NORTH WEST RAIL LINK – CONSTRUCTION EIS OVERVIEW

Figure 10.3 Location of sensitive receivers near Cheltenham Services Facility

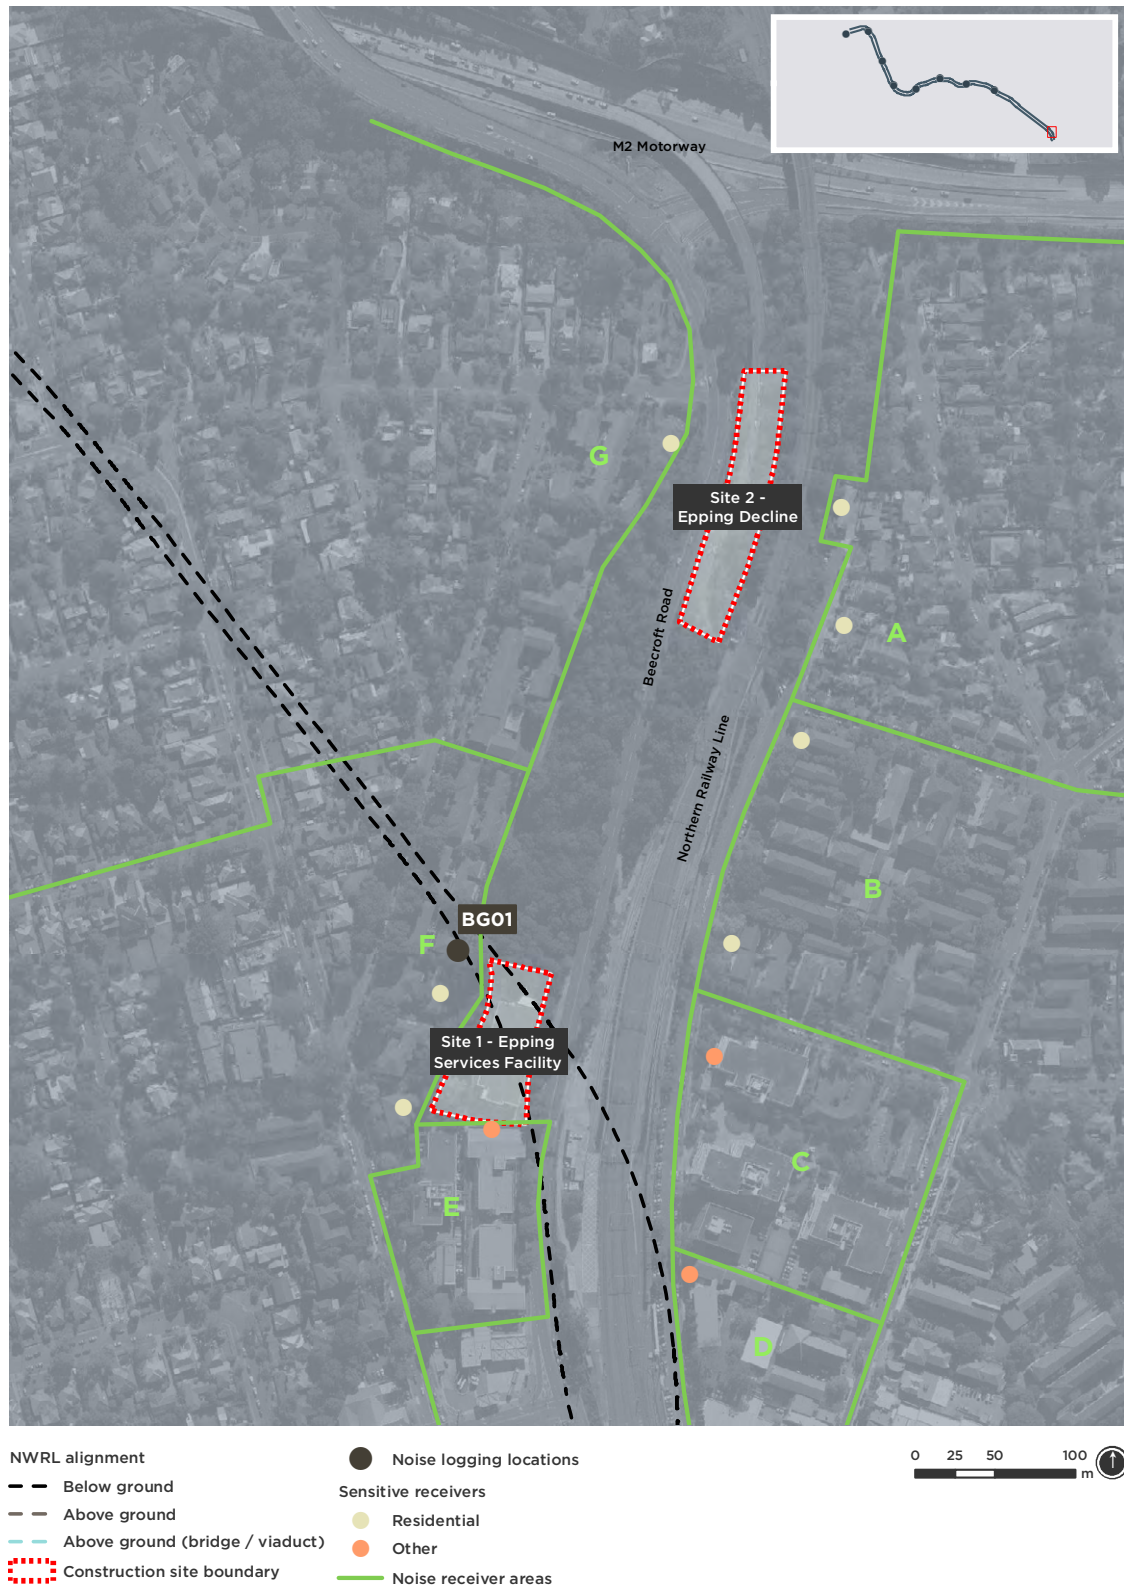
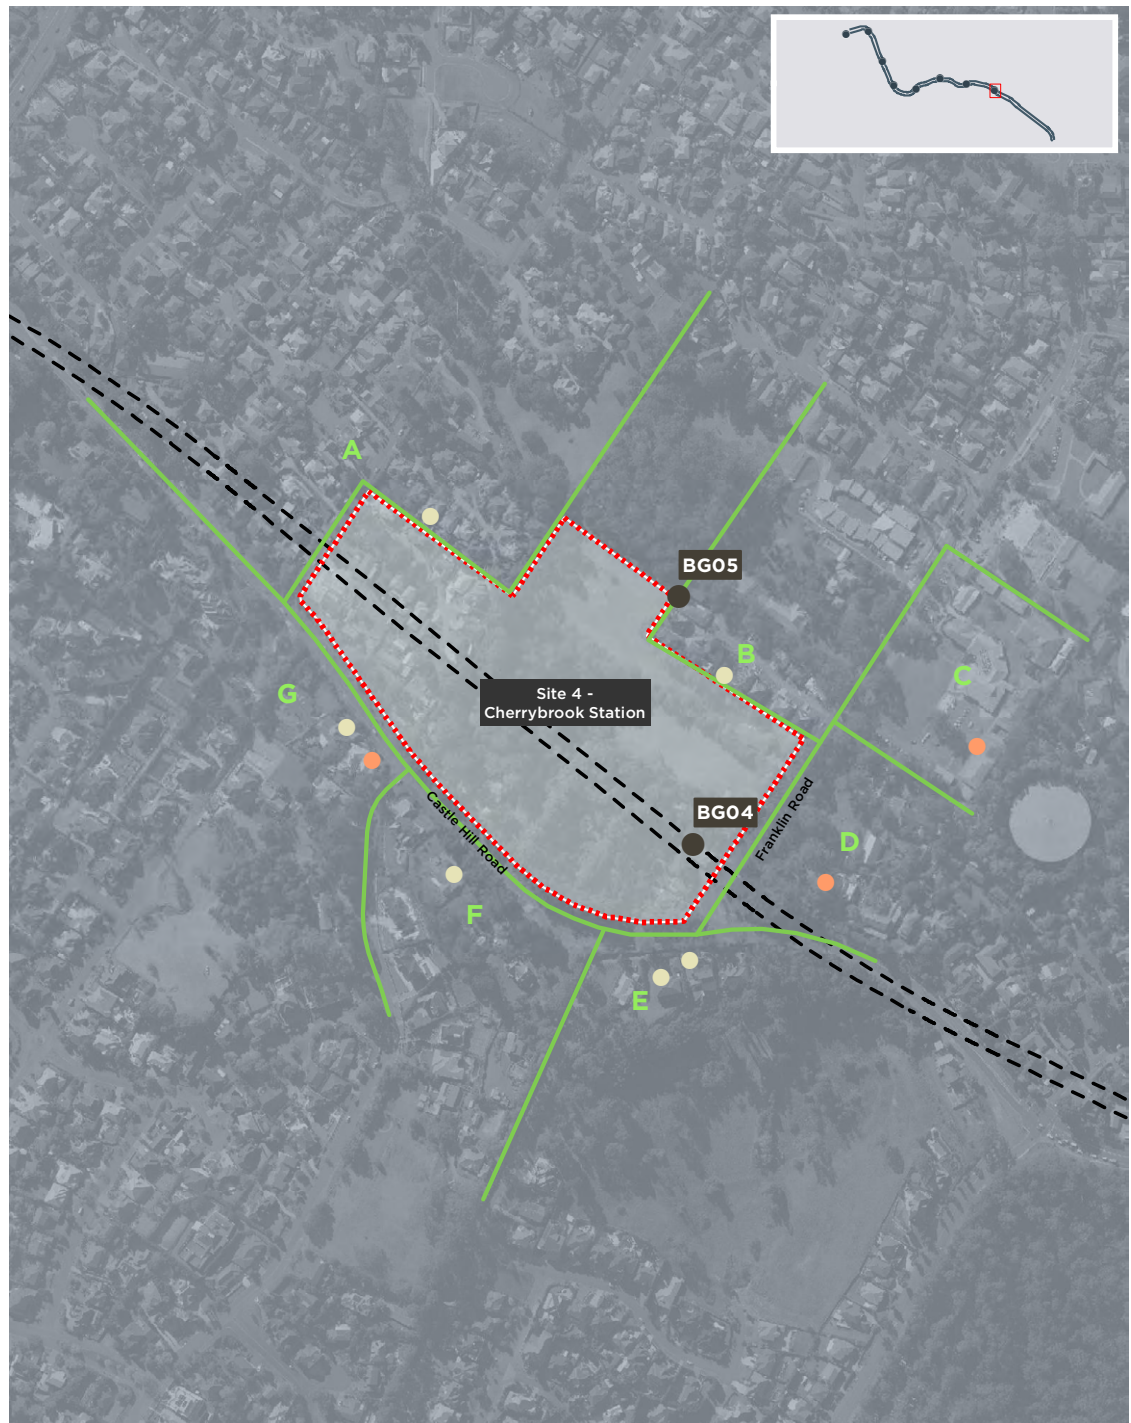
<p>10. NOISE AND VIBRATION CONSTRUCTION</p>	
<p>10.7.2 Epping Service Facility and Epping Decline</p> <p>10.7.3 Cherrybrook Service Facility</p> <p>10.7.4 Cherrybrook Station</p>	<ul style="list-style-type: none"> • Concerns are raised with regard to predicted noise exceedances. Notably, the anticipated exceedance of more than 20 dB of the Noise Monitoring Levels during site establishment and rock excavation at the Cherrybrook site. Further, moderate to high exceedances are predicted at services facility construction sites. Whilst further acoustic mitigation measures have been identified such as periodic notifications, project info-line, phone calls, briefings, respite offers and alternative accommodation, the EIS appears to indicate that noise will continue to impact upon residents and the community. Further mitigation measures which reduce noise impacts upon residents should be considered.

Cherrybrook - HBT

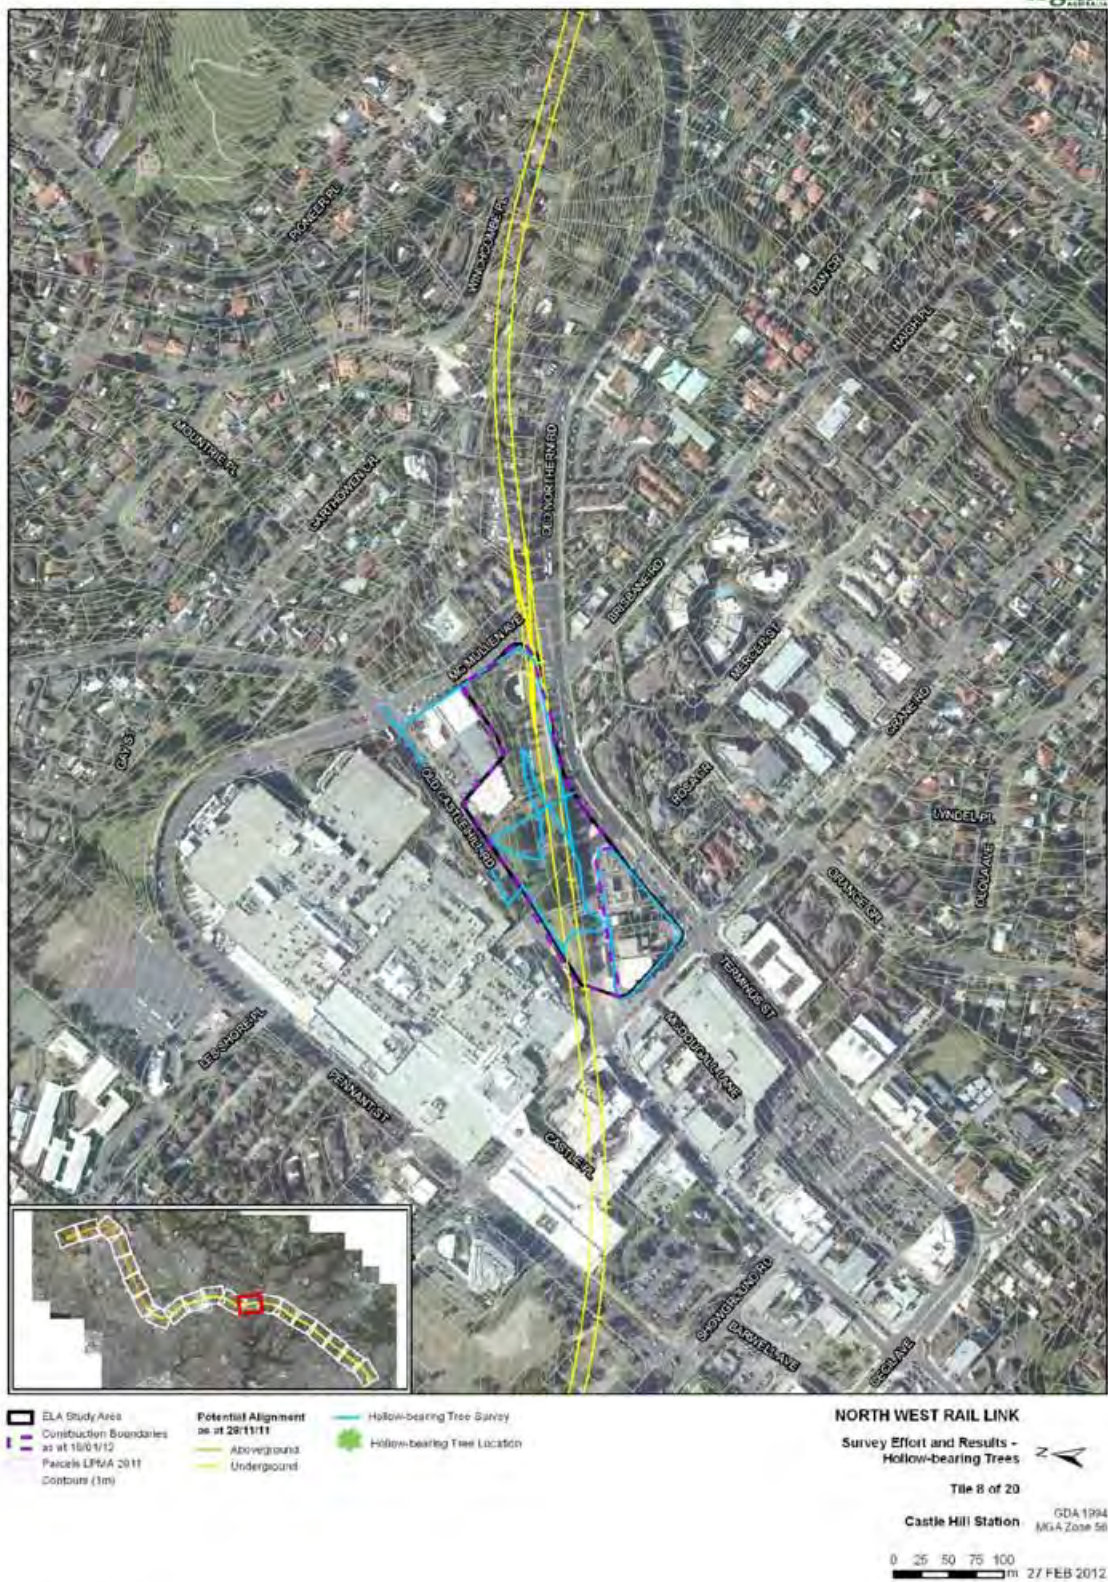
<p>residents of Cheltenham and Epping, but also provides a vegetated scenic corridor adjacent to M2 motorway.</p> <ul style="list-style-type: none"> • It is considered that the removal of remnant trees, including some old growth specimen trees of individual significance will have a major adverse impact on the continuity of the corridor and a significant adverse impact on the landscape qualities of the visual catchment and the landscape qualities of the <i>Beecroft/Cheltenham Heritage Conservation Area</i>. In addition to the need to provide biodiversity offsets in association with the proposed tree removal, it is appropriate that opportunities be investigated to provide supplementary/replacement planting of trees within the immediate vicinity of the item to mitigate the visual impact of the construction of the facility. Consideration should also continue to be given to the investigation of alternative options that will reduce the scale of impact on the heritage listed corridor. • Under Site 3 <i>Cheltenham Services Facility</i> 7.9.3 (p. 7-22) the option to construct the access road directly off the M2 Motorway is being investigated. COMMENT: this option needs to be fully investigated with a view to reducing impacts of clearing of good condition vegetation, reducing impacts of fragmentation and reduction of remnant by approximately 25% and recognising concerns expressed by the Chilworth Bushcare Group and the Beecroft Cheltenham Civic Trust. • Under <i>Survey Limitations</i> (p. 15-9), the EIS notes that hollow bearing tree surveys have not been carried out in certain areas of the Cheltenham site. Figure Cheltenham HBT on page 164 of Technical Paper 5a identifies the areas that hollows have been identified. Further, Technical Paper 5a, 4.5 <i>Key Threatening Processes</i> (p. 69) notes that the loss of hollow bearing trees is to be compensated for through the delivery of vegetation community offsets. Under 15.5.2 <i>Terrestrial Fauna</i>, the EIS identifies the loss of 9 potential breeding hollows and indirectly impacting on 8 additional hollows suitable for the Gang-gang Cockatoo. This population is restricted to the Hornsby and Ku-ring-gai LGA's. The EIS also states that the loss of 2 potential roosting hollows and indirectly impacting 1 additional hollow for the Powerful Owl and Barking Owl in Cheltenham and Cherrybrook. COMMENT: The EIS appears to have omitted surveying hollow-bearing trees in the west part of the Cheltenham

<p>site including the proposed access roads leading from Kirkham Road and Castle Howard Road into the Cheltenham Service Facility. It is important that surveys of hollow bearing trees be undertaken in these locations prior to construction so that potential impacts on this habitat can be mitigated. Appendix N (Offset Strategy) has not provided for the offsetting the loss of hollows or nesting sites which needs to be included. It is recommended that where possible any hollows from trees to be removed from the site be placed back on the site to provide potential nesting habitat. If naturally occurring hollows are not suitable for placing back in the site then artificial hollows should be placed back in the site to maintain nesting habitat.</p> <ul style="list-style-type: none"> • Under <i>Threatened Flora</i> (p.15-11) and <i>15.5.1 Terrestrial Flora</i> (p.15-24), the EIS notes that the <i>Epacris purpurascens var purpurascens</i> is located outside the construction footprint. <u>COMMENT:</u> The <i>Epacris</i> is potentially located within the footprint of the access road off Kirkham Street. It is also important that additional site surveys need to be undertaken as per Mitigation Measure E3 Table 15.11. Council may be contacted to provide advice on the location of the plants. Consideration should be given to translocation of the plants as well as trialling the propagation of <i>Epacris</i> from seed. • Under <i>Outside the North West Growth Centre</i> (p. 15-29), the EIS identifies the Critically Endangered Ecological Communities (EPBC Act) and the removal of Blue Gum High Forest and Sydney Turpentine Ironbark Forest within Hornsby LGA. Also in <i>15.4.2 Terrestrial Flora</i> (p. 15-13), the EIS notes that Blue Gum High Forest has been identified at only one site, Cherrybrook Station. Sydney Turpentine Ironbark Forest has been identified at the Epping Services Facility and Epping Decline site. <u>COMMENT:</u> It is important that effective offsets be provided within the Hornsby Shire as per Table 34, Offset Strategy, Appendix N, Technical Paper 5a. • Under <i>15.4.2 Terrestrial Flora</i> (p. 15-13), Coastal Shale – Sandstone Forest has been identified at the Epping and Cheltenham sites. Table 34, Offset Strategy, Appendix N, Technical Paper 5a lists that 3.03 ha. of Blue Gum High Forest within Hornsby LGA, 5.75 ha. of Coastal Shale – Sandstone Forest within Hornsby LGA and approximately 0.17 ha. of Sydney Turpentine Ironbark Forest within Hornsby LGA are to be offset. <u>COMMENT:</u> The
